PROJECT NAME
WALGREENS STORE
(RWC) PASEO DEL NORTE & VENTURA
ALBUQUERQUE, NM

DRAWING TITLE
INTERIM DRAINAGE MANAGEMENT PLAN

**Re: Paseo del Norte and Ventura Blvd Development, Drainage Management Plan
Engineer's Stamp dated 11-9-09 (D20/D010)**

DRAINAGE MANAGEMENT PLAN

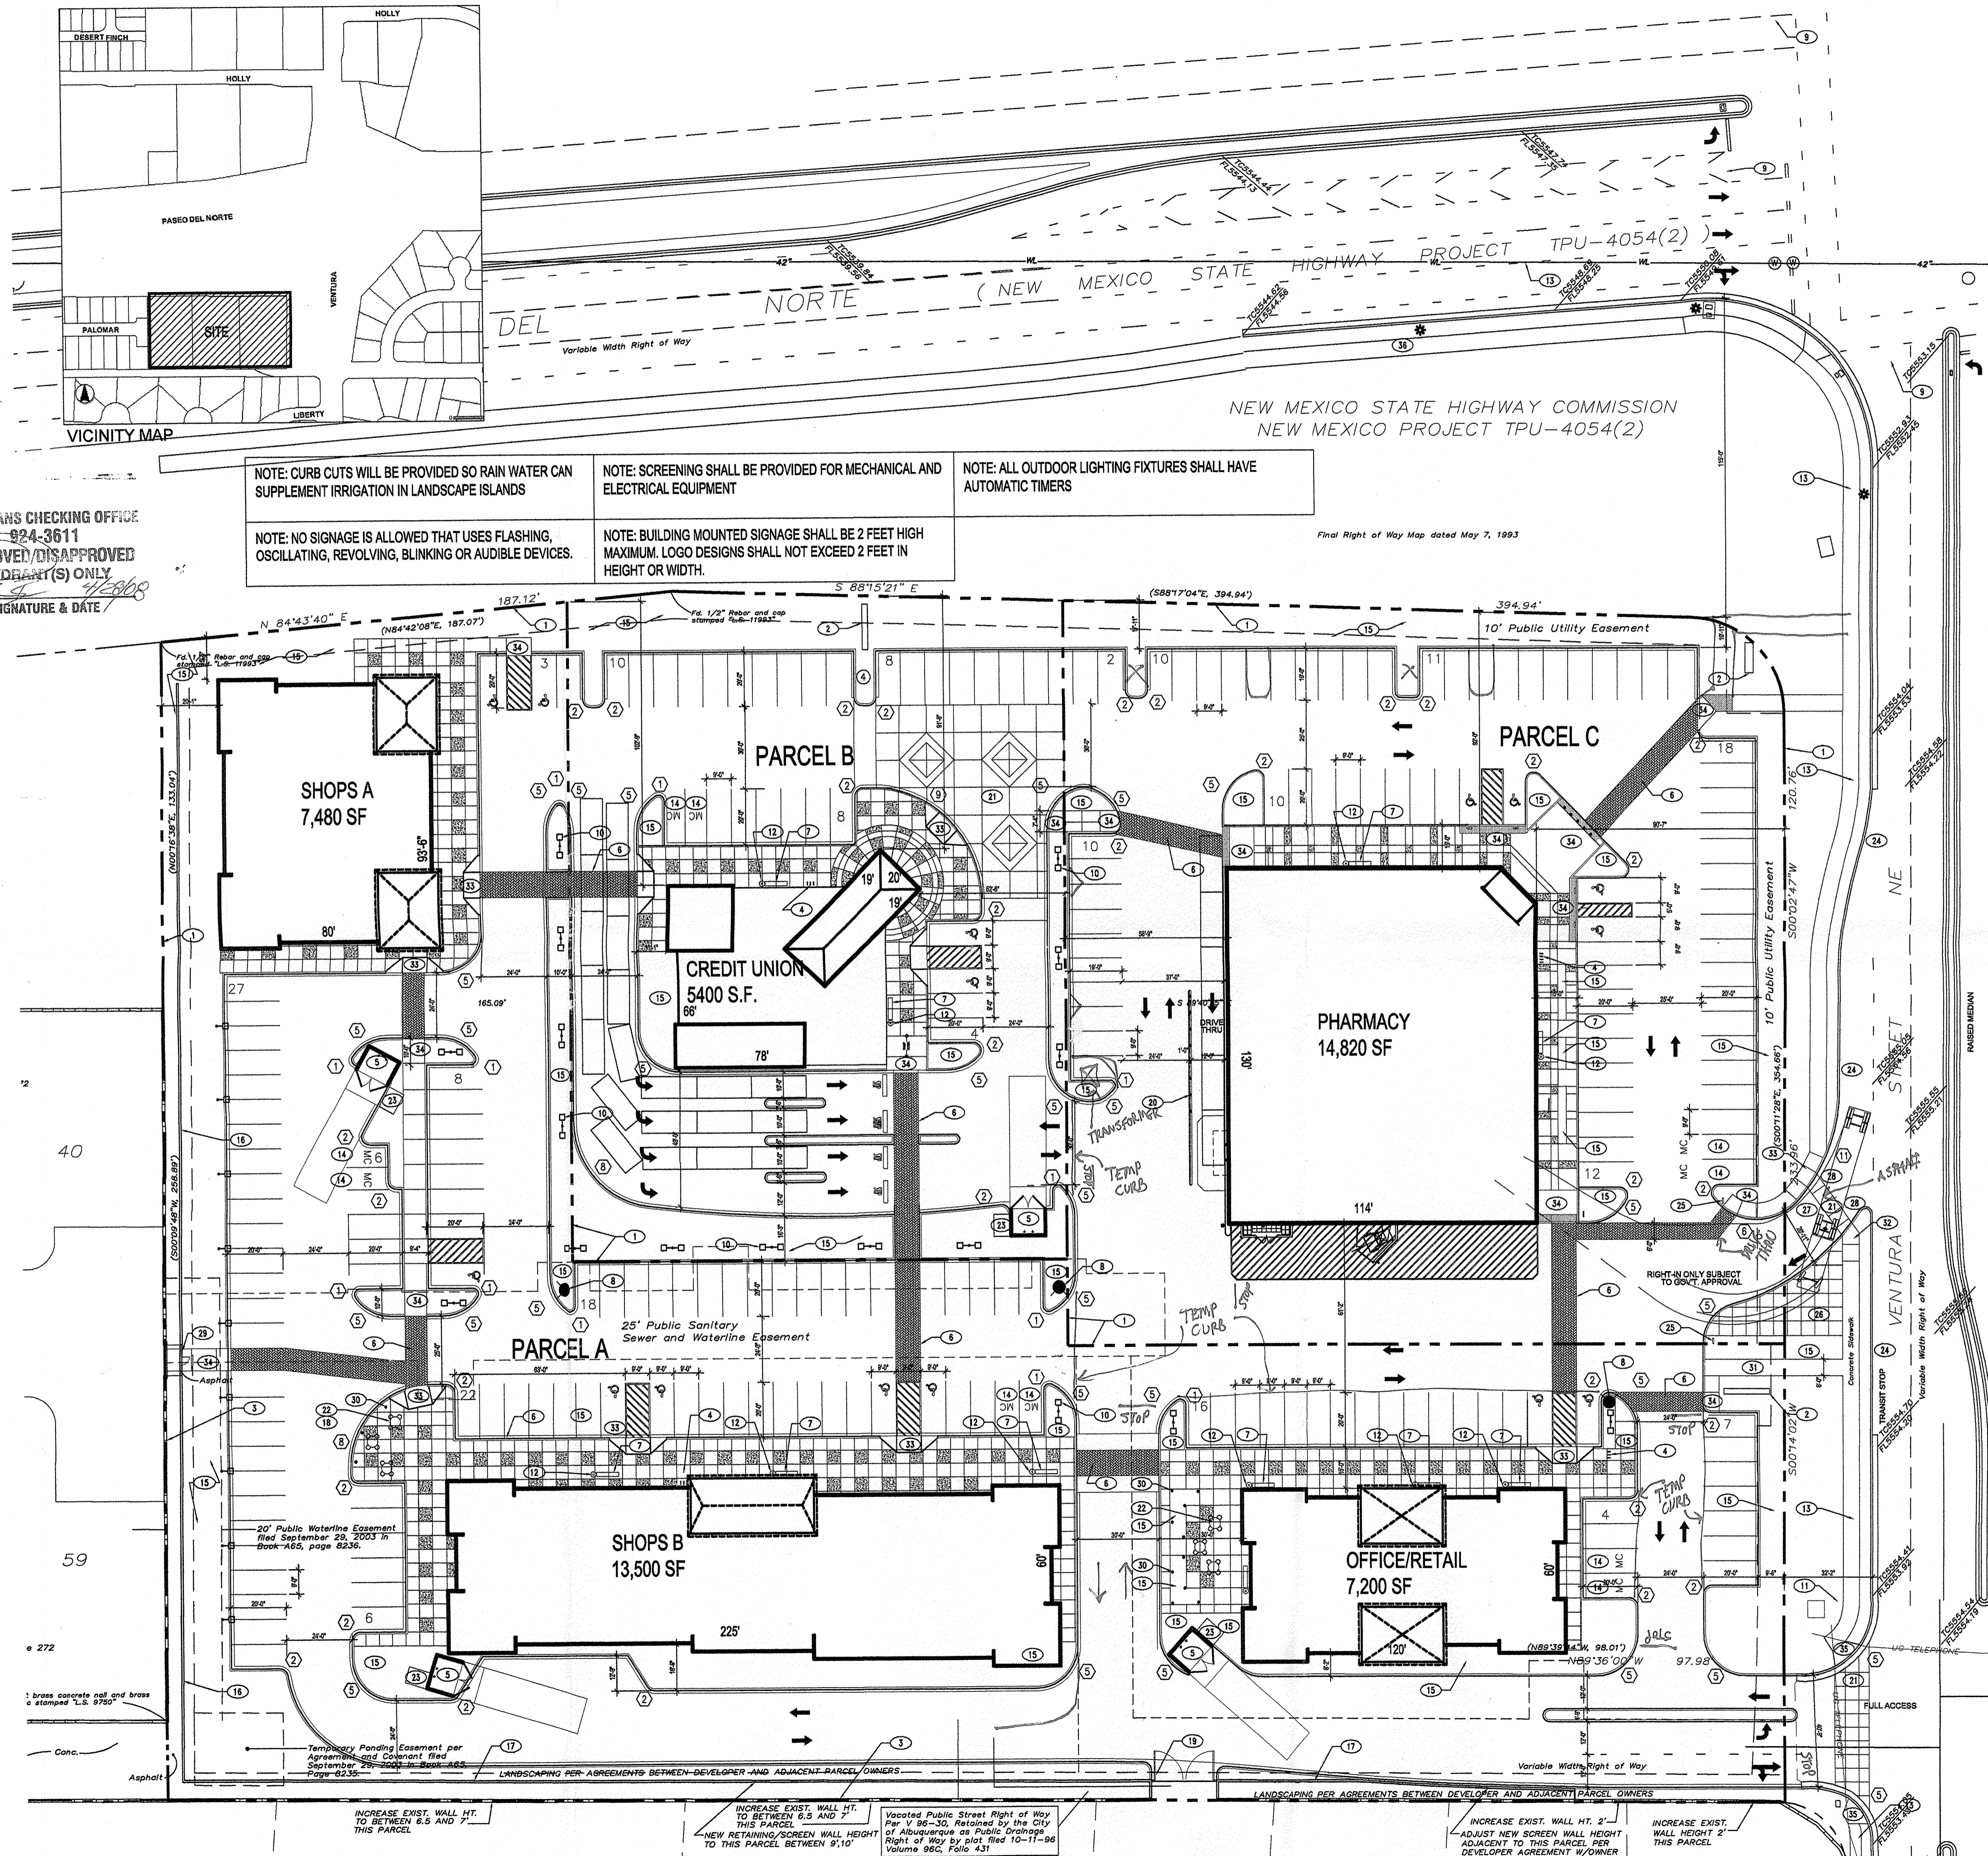
Based upon the information provided in your submittal received 11-9-09, the above referenced plan is approved as the Drainage Management Plan for this development with the comment that Basin C should have been included in the list of Basins draining to the Paseo del Norte system in the narrative.
